**Consultation Response from Mike Hibbert,
KC Waste Strategy(Refuse & Recycling)**

2022/92842 The Carlton Nursing Home, 25, Greenway, Milnsbridge, Huddersfield, HD3 4RZ

Change of use and internal alterations to former nursing home (C2) to form 12 apartments (C3)

The applicant has submitted revised Proposed Layout and Elevations Dwg No 2206/02A dated 5/02/2024 that incorporates provision for two waste stores.

CLIENT	Mr Nasaar				
ADDRESS	25 Greenway, Longwood HD3 4RZ				
PROJECT	Change of use C2 to C3				
DRAWING	Proposed Layout and Elevations				
DRAWN	UH	DATE	Aug 22	SCALE	1.100@A1
DWG No.	2206/02A				
STATUS	PLANNING

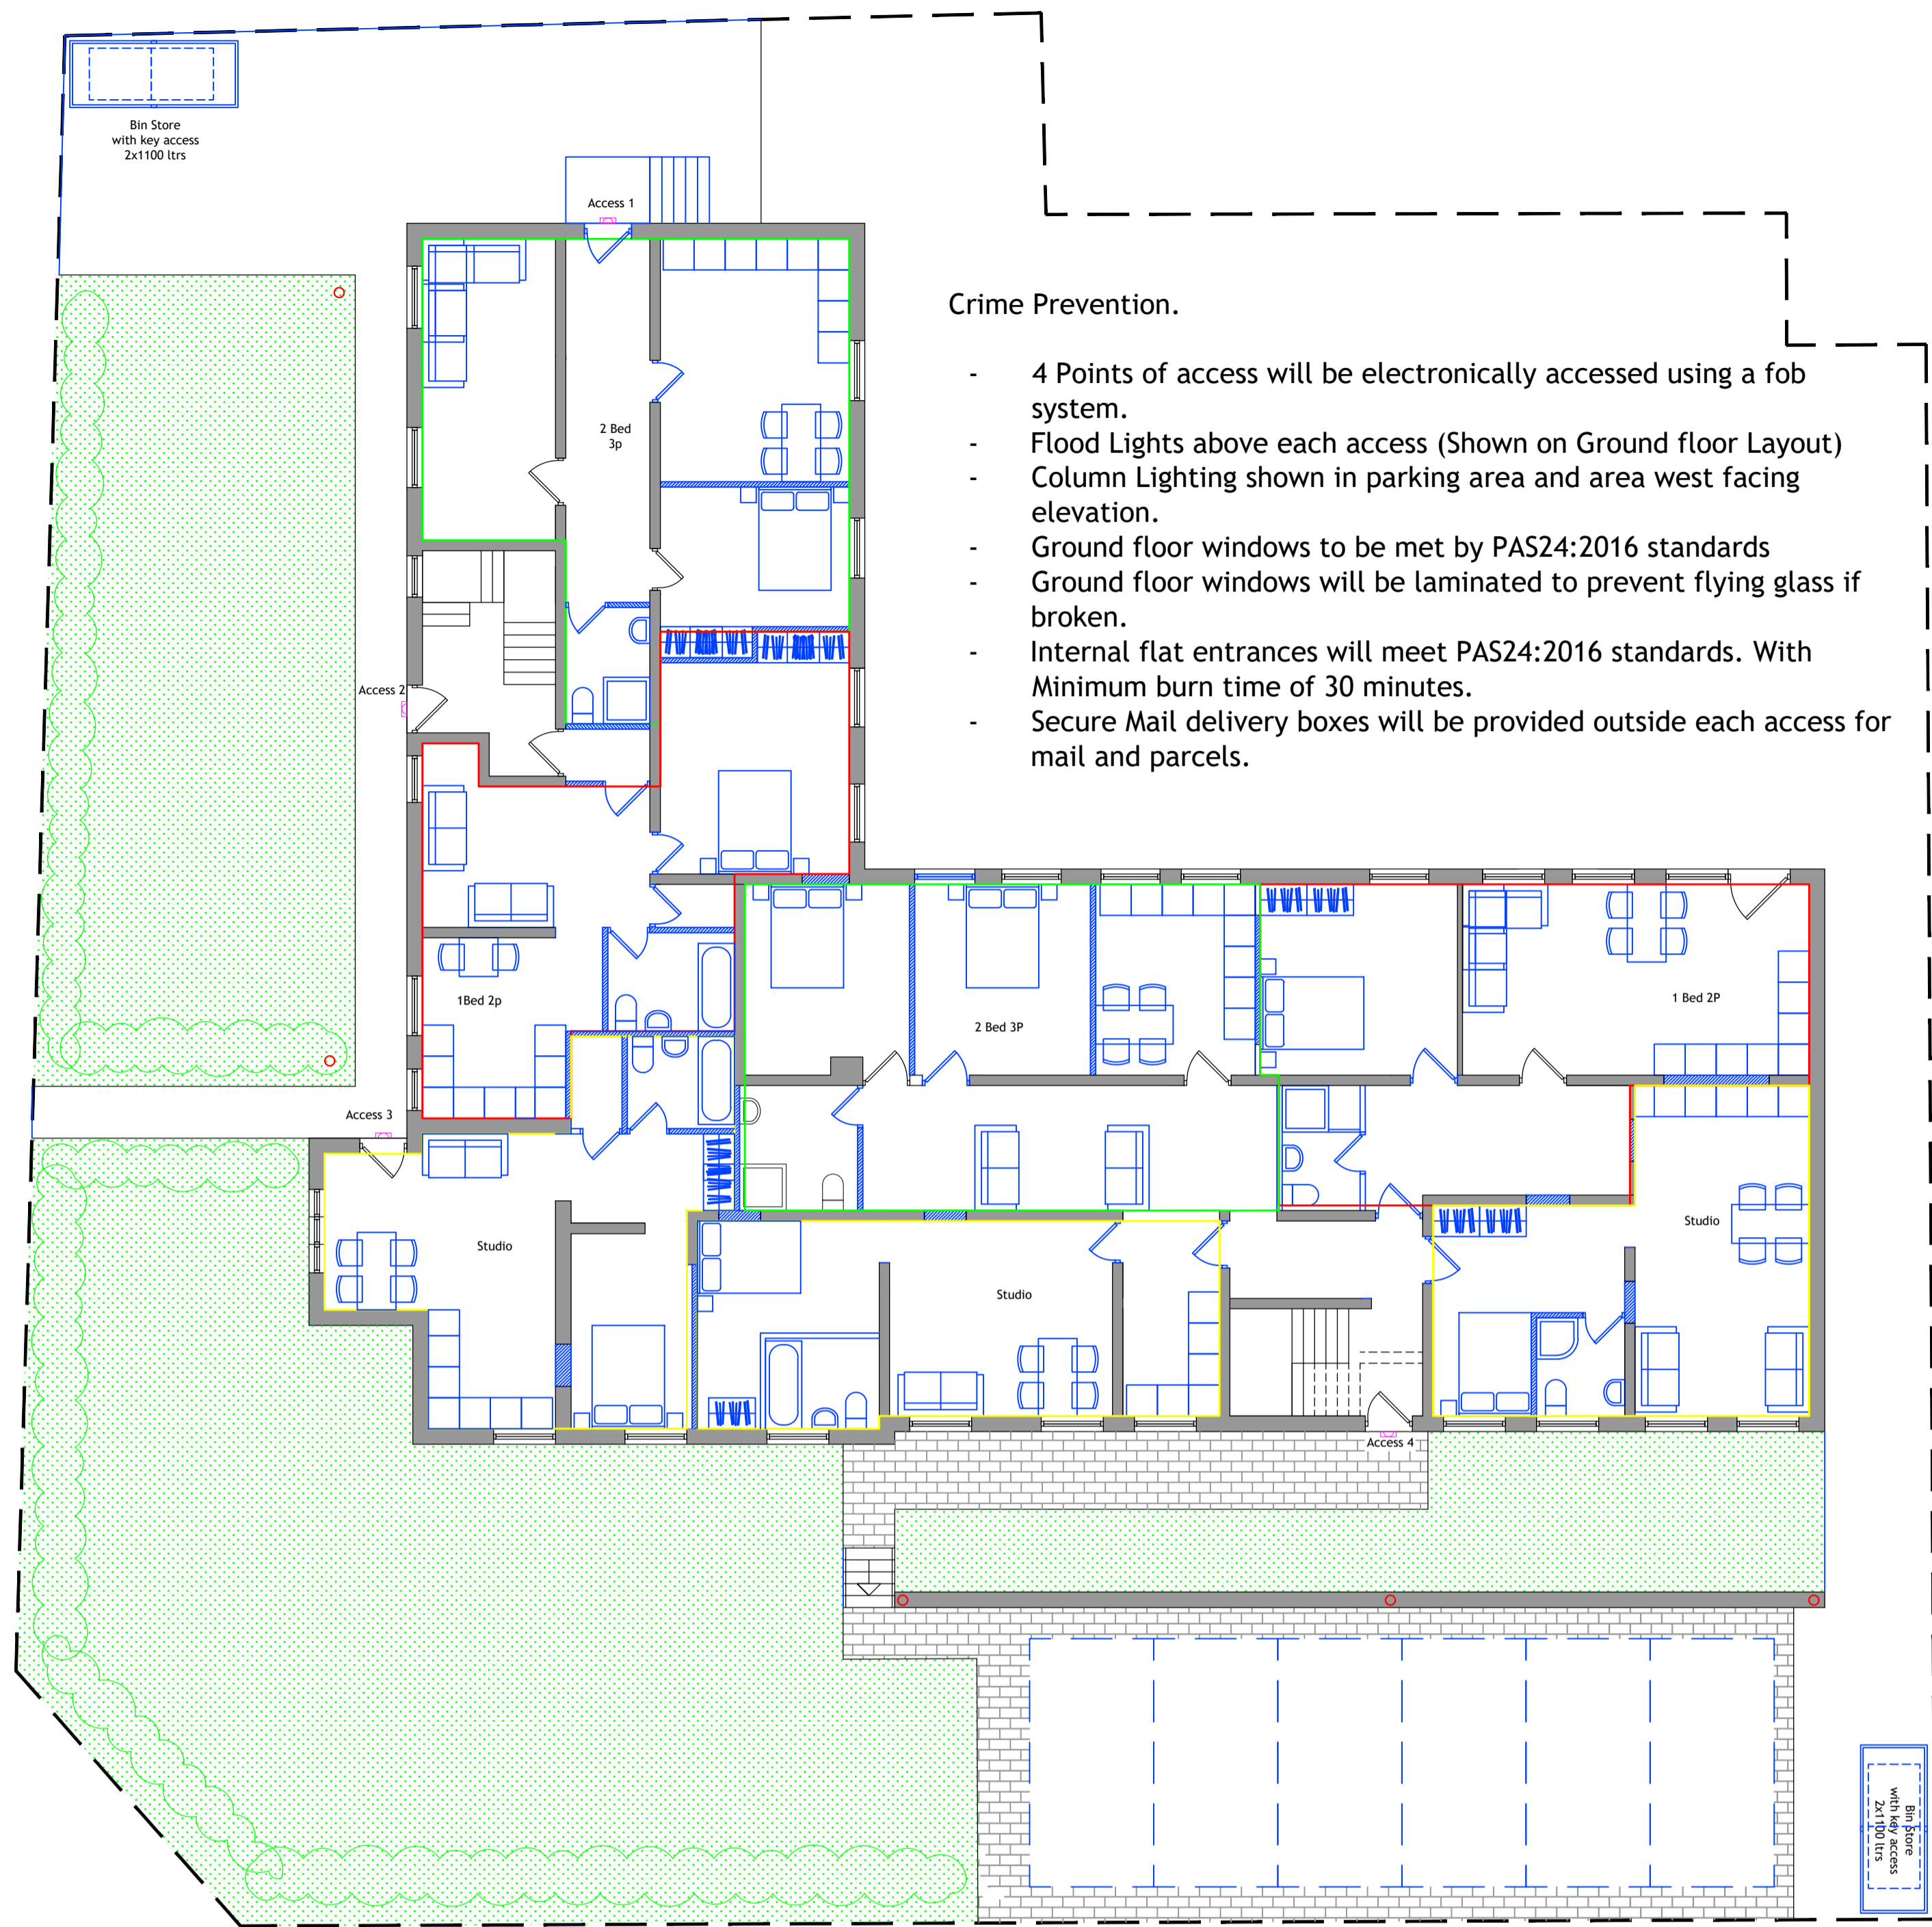
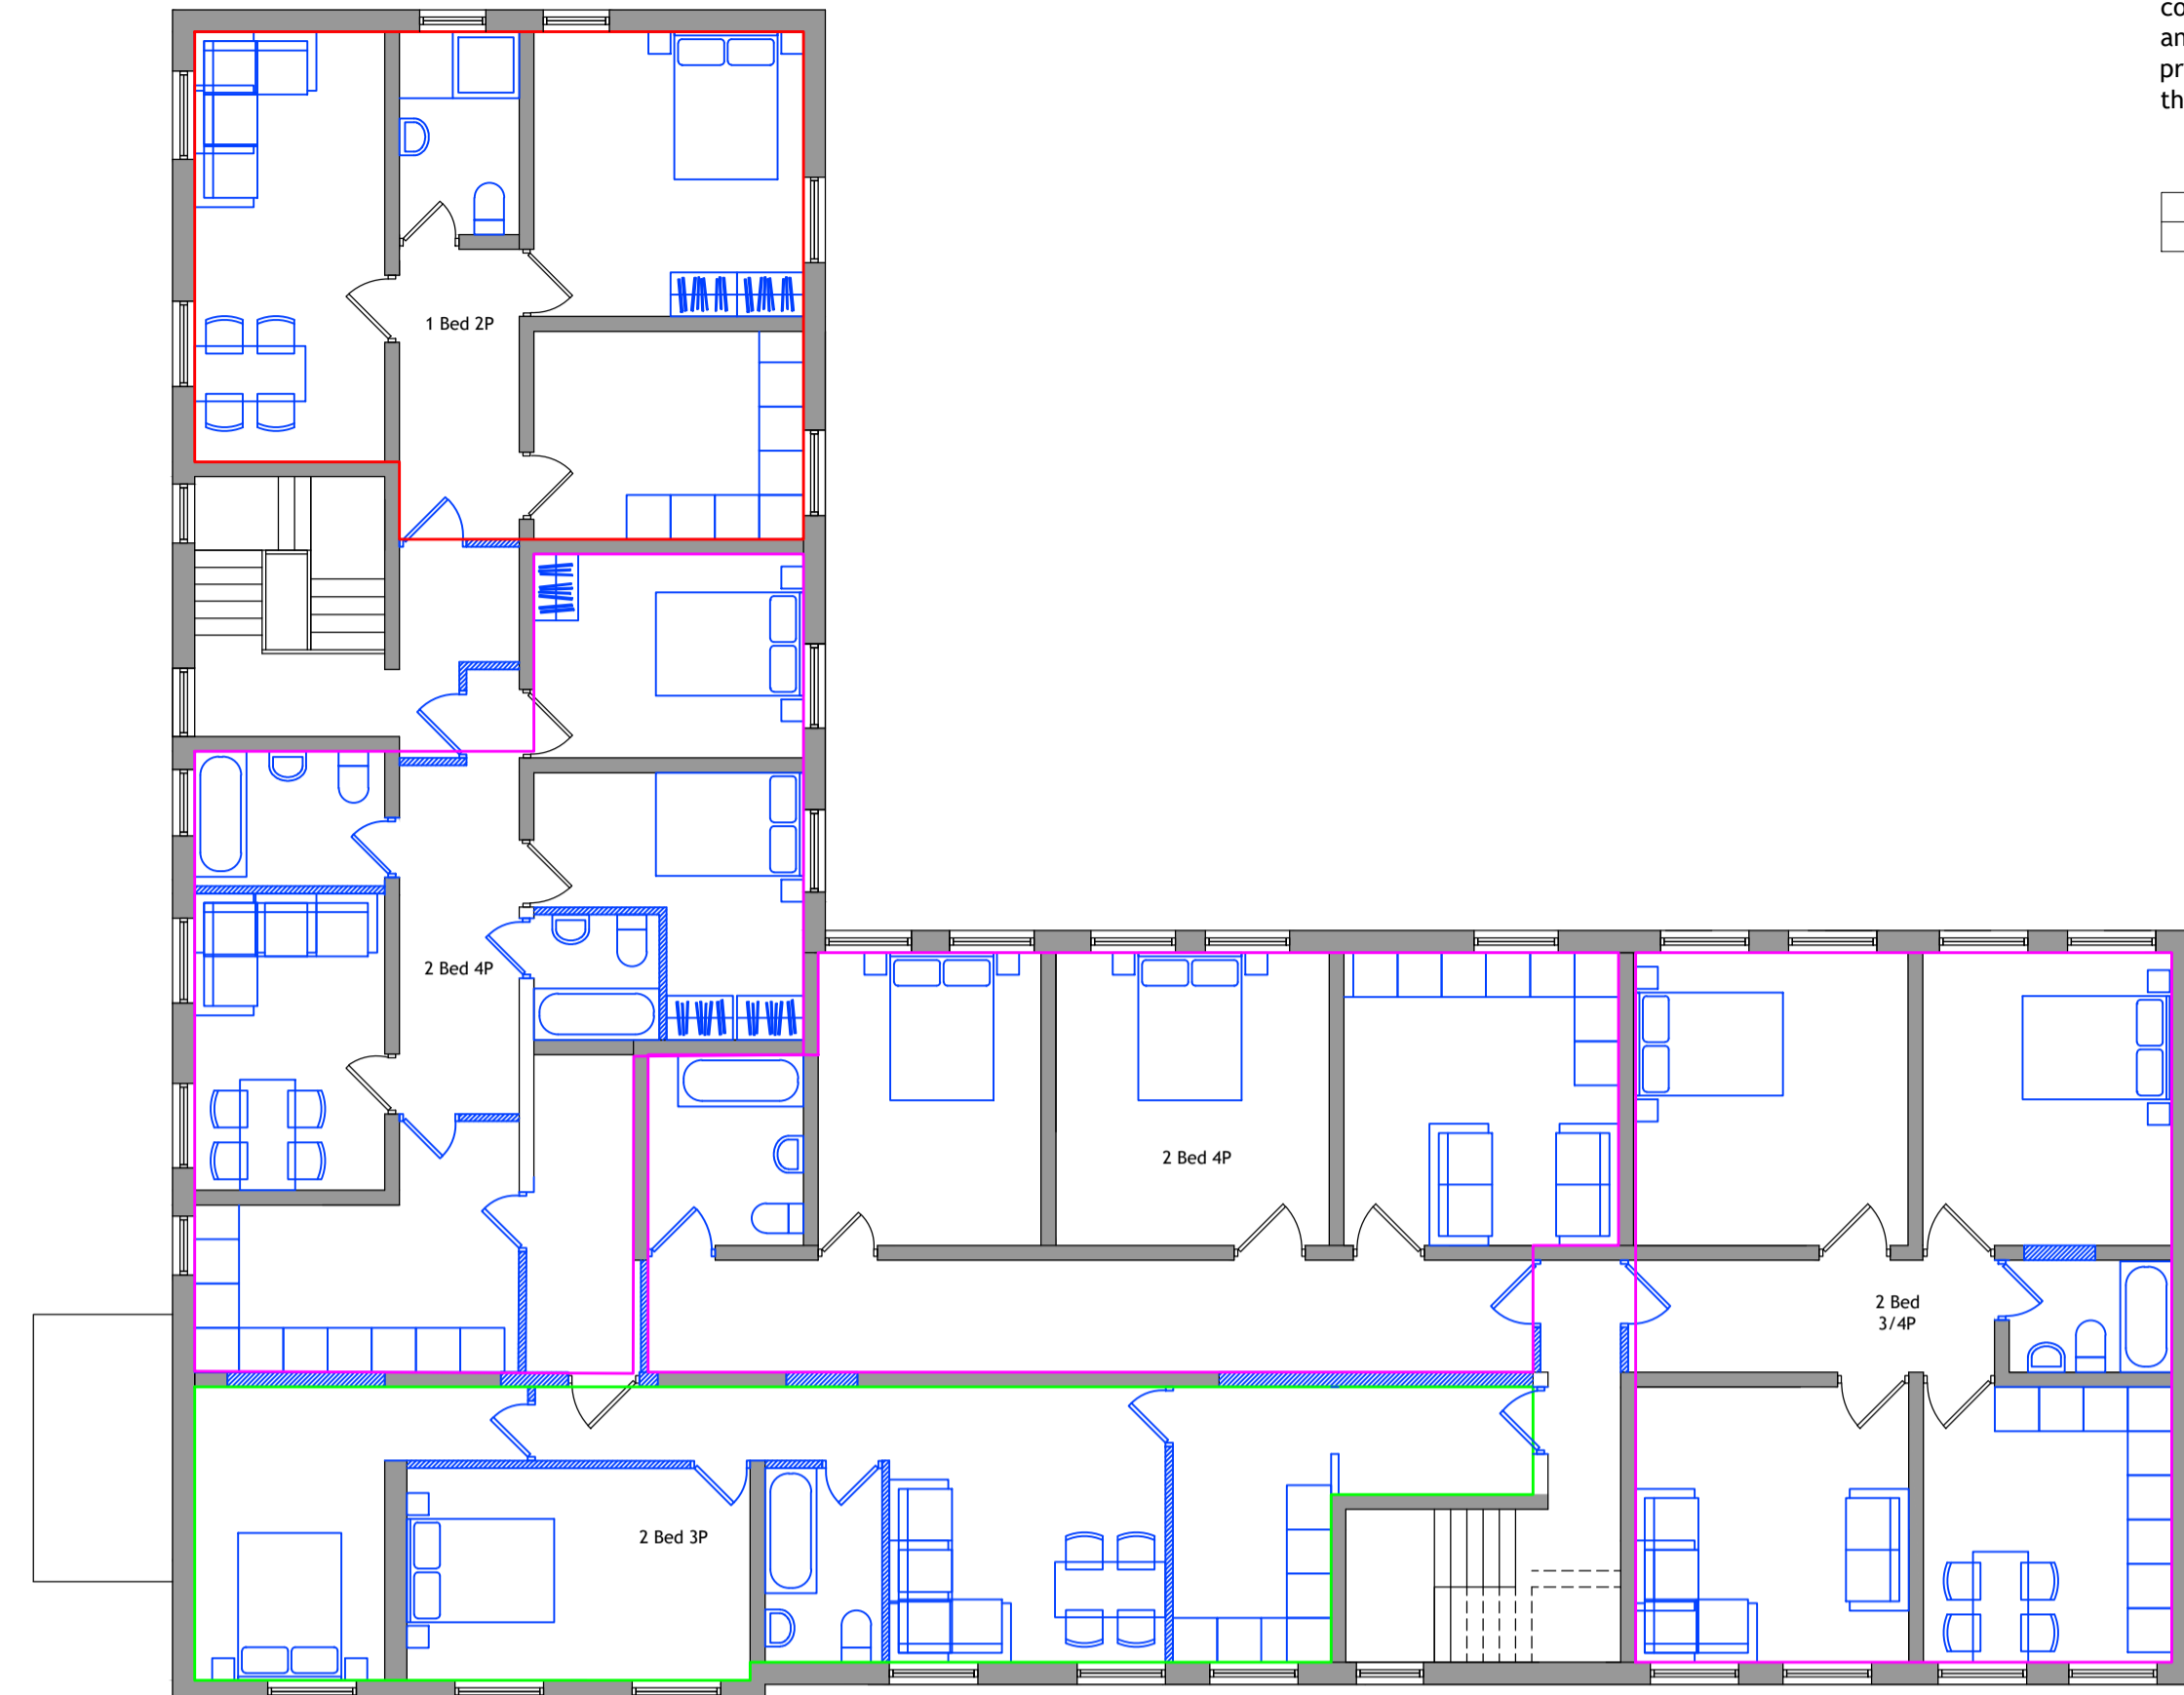
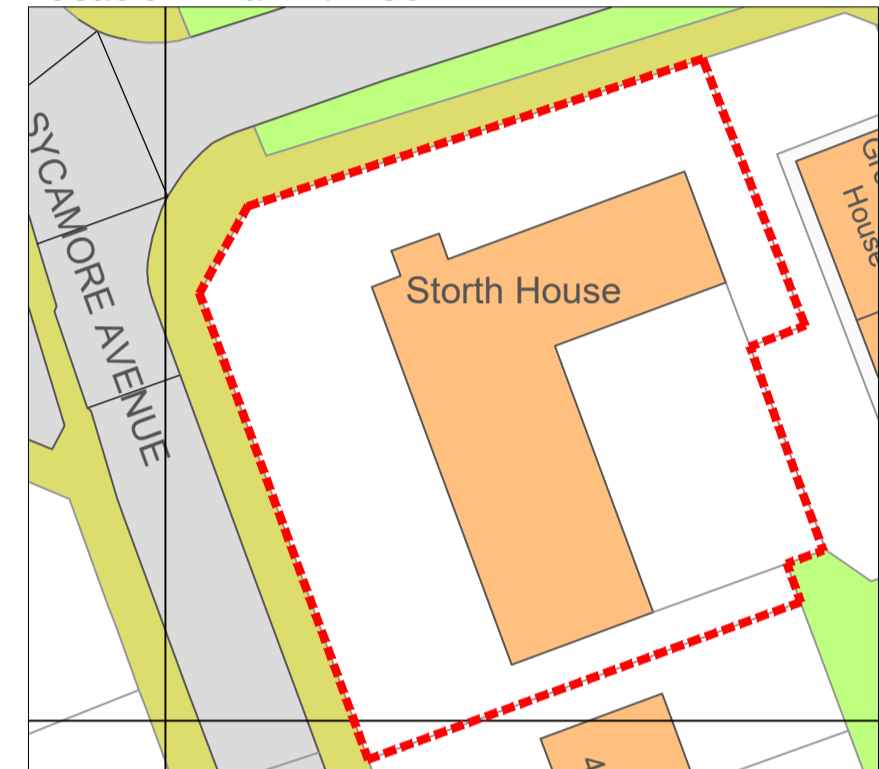
- For 12 apartments the recommended waste storage provision is 2160 ltrs. Appropriate waste storage provision would be 4 x 660 ltrs wheeliebins. (2x Recycling and 2x residual). It is welcomed that two bin stores (two bins in each) are shown on the plan, located at each end of the building with a walk distance from the entrances to the bin stores being within the 30m specified in guidance BS5906:2005.

- Guidance indicates the floor space for a 660ltrs wheeliebins is 1360mm x 770mm with space to manoeuvre the bins within the store so the bin store dimensions at approximately 1.5m x 3.4m should be large enough. Additional information is required detailing screening and surfacing. Bin store surfaces should be durable and waterproof enough to withstand heavy duty cleaning such as power washing.

- The waste stores should be secure to prevent theft, unauthorised use/ fly tipping or rough sleeping. It is welcomed that on the plan it details that the stores will have key access for residents. If the doors to the bin store are to have a key/keypad to secure access these details will be required by the collection staff.

- The bin storage access routes to the Bin Collection Point (BCP) should be constructed to withstand point loading and movement, impacts of larger bins over time, and to resist future rutting, pitting, cracking or other such surface degradation that would impair bin manoeuvring. To facilitate loading of full wheeliebins the surface between the bin store and BCP/ highway should be smooth hard surface without kerbs. The

proposed layout must ensure that parked cars do not obstruct the route between the bin store and loading point.

“Before development commences, details of the management and maintenance of communal refuse storage areas by a designated private management company shall be submitted to and approved by the Local Planning Authority. The approved details shall be provided before first occupation and shall be so retained thereafter”.
